From: Gorman, Sarah [Sarah.Gorman@lancashire.gov.uk]
Sent: 18 June 2012 15:20
To: planning
Subject: 03/2012/0399 - land to the rear of Higher College Farm - ecology response
Attachments: 03 12 0399 ecology response.pdf

Planning Application No: 03/2012/0399

Proposals: Creation of a private swimming pool for teaching purposes. The pool will only be open for pre-booked lessons.

Ecological comments

Swim School - Site Plan

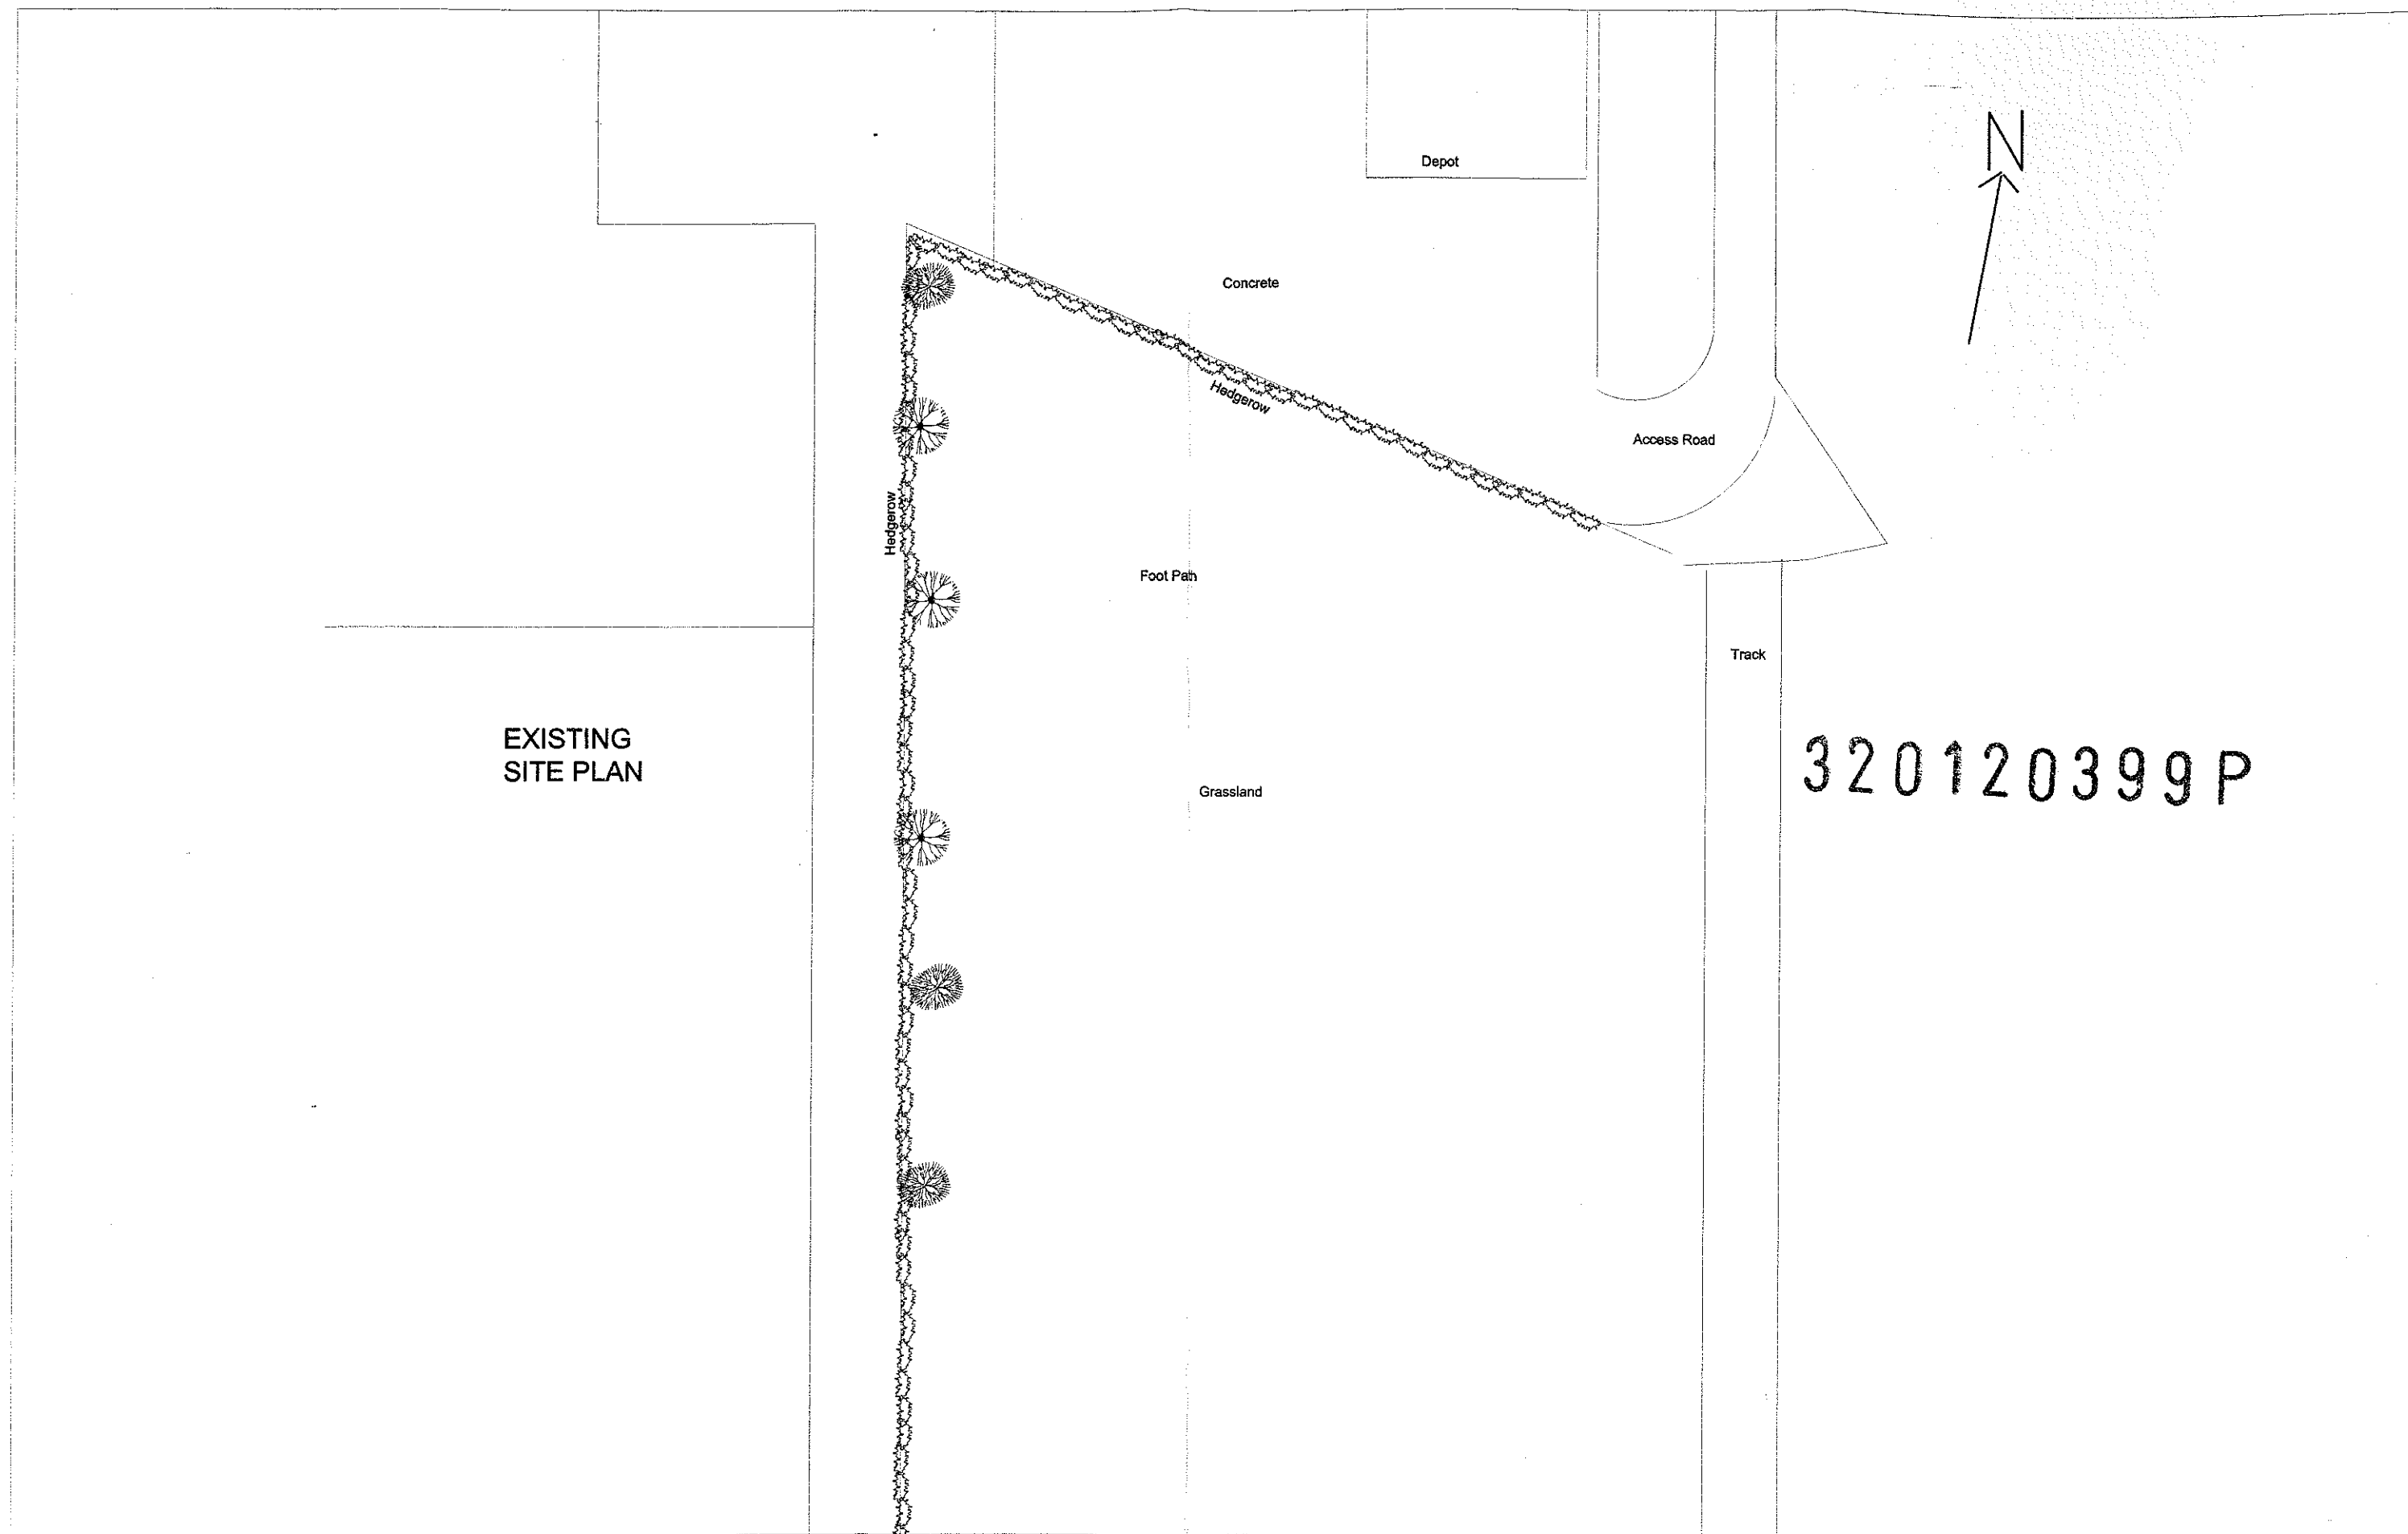
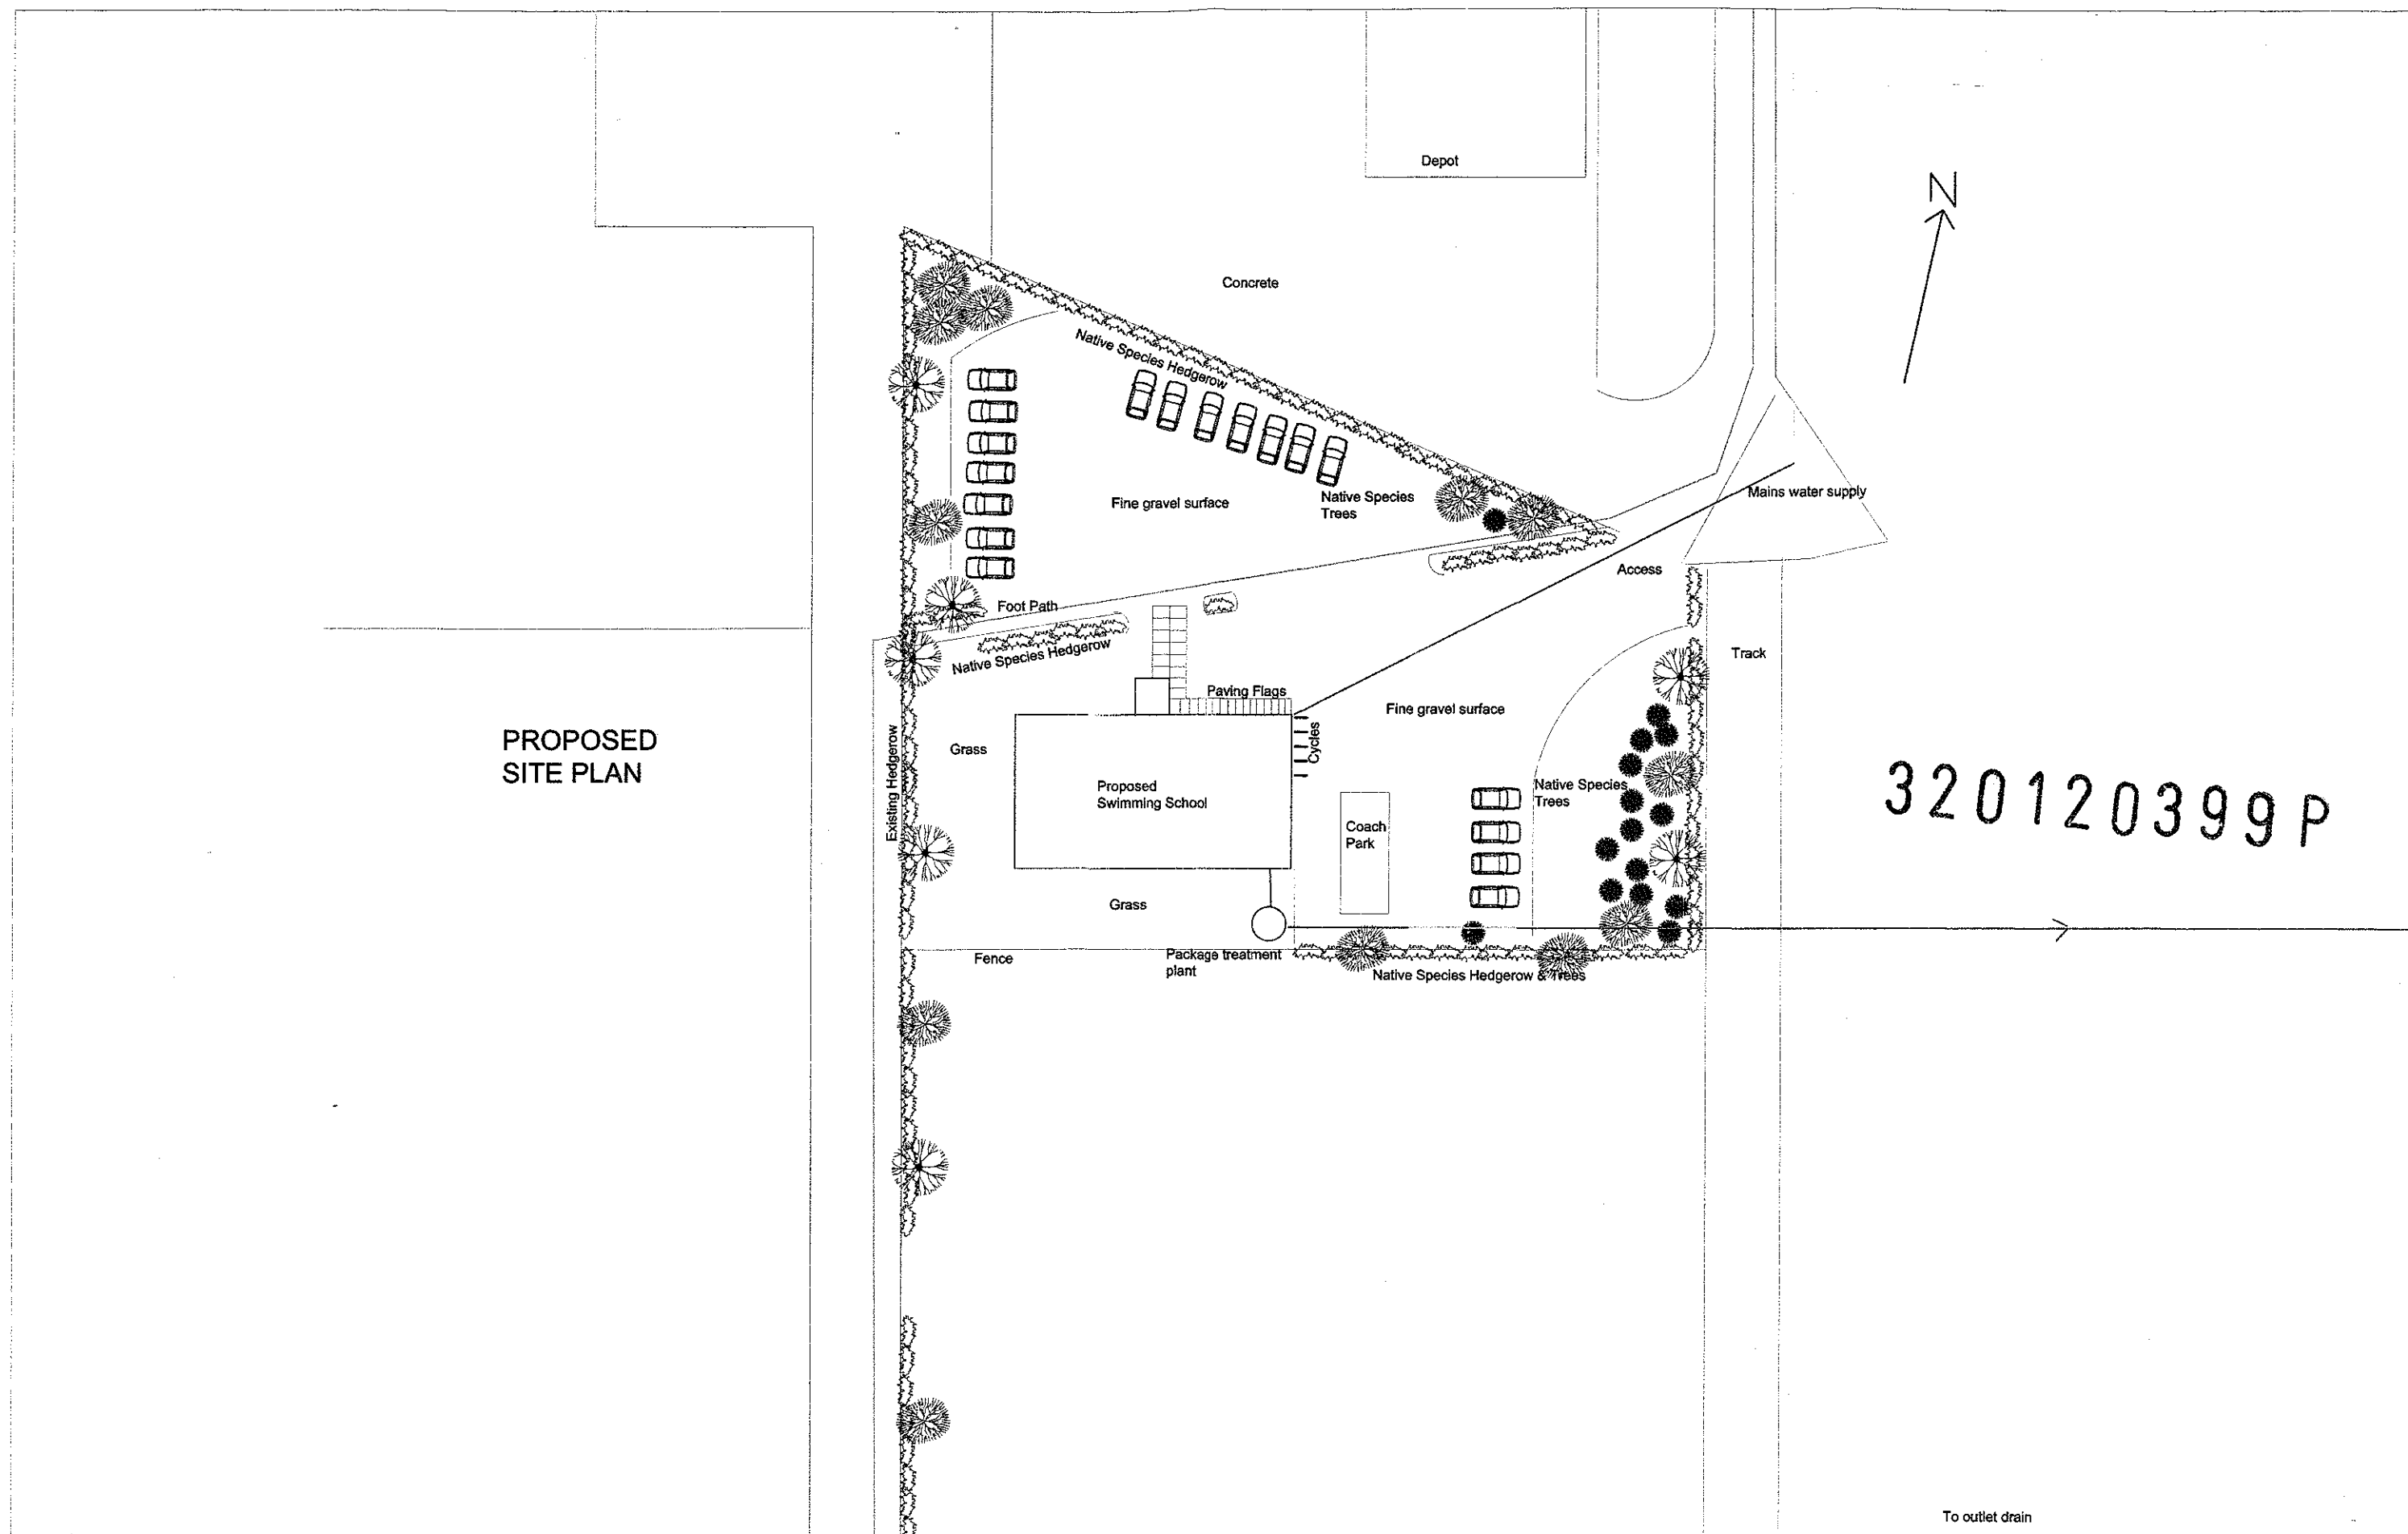
Hedgerows with mature trees are present to the north and west of the site. The hedgerows may qualify as a Habitats of Principal Importance. DEFRA Circular 01/2005 indicates that UK Biodiversity Action Plan Priority Species and Habitats (Species and Habitats of Principal Importance, NERC Act 2006) are capable of being a material consideration in the making of planning decisions.

The proposed layout appears to show hard-standing in close proximity to the hedgerows and trees. The roots of hedgerows/trees on the site boundary could be adversely affected by the proposed building work. A planning condition is recommended above to address this matter.

- All trees/hedgerows being retained in or adjacent to the application area will be adequately protected during construction, in accordance with existing guidelines (e.g. *BS5837: 2005 Trees in relation to construction - Recommendations*).
- If the presence of any protected species that may be affected by the proposed works is detected or suspected at any stage before or during the proposed works, then works should cease until ecological advice has been sought.
